**DEVIATION REQUEST  
AND DECISION FORM IN  
ASSOCIATION WITH A  
REQUEST FOR A PUD  
MODIFICATION FROM  
THE ECM**

A deviation from the standards of or in Section **ECM2.2.4.B.7 (Figure 2-17), Table 2-7, ECM 2.3.3.F.3 and standard detail SD\_2-2** of the Engineering Criteria Manual (ECM) is requested.

**WATERSIDE TOWNHOMES**  
 DEVIATION REQUEST - ECM SEC. 2.2.4.B.7.  
 FIGURE 2-17, TABLE 2-7  
 PCD FILE NO. PUDSP-22-009

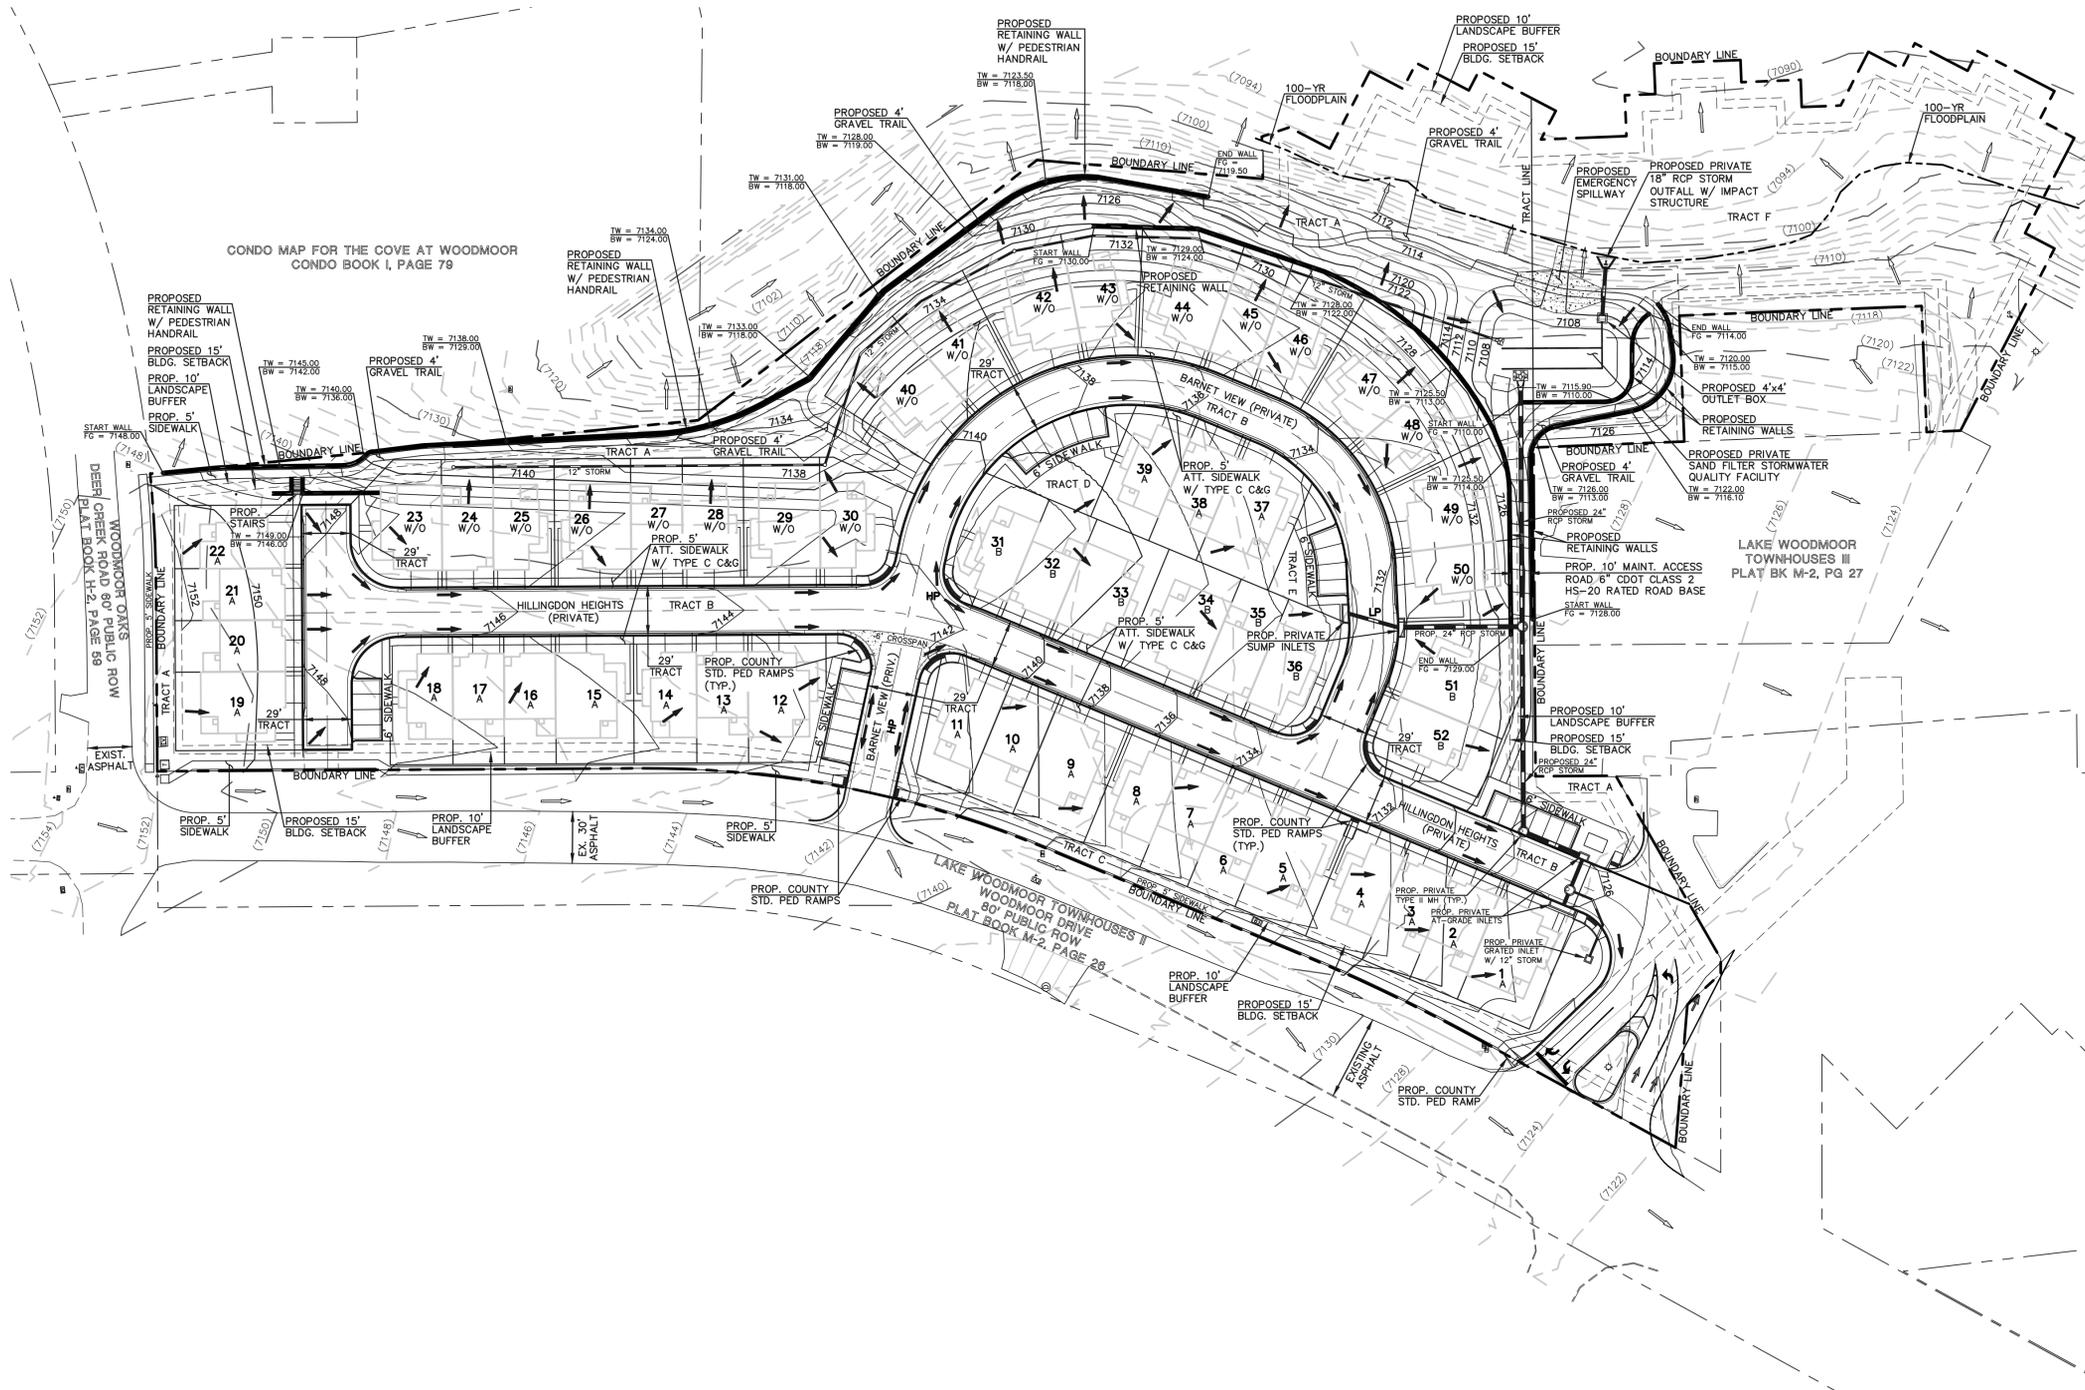
delete highlighted text

Delete highlighted statement
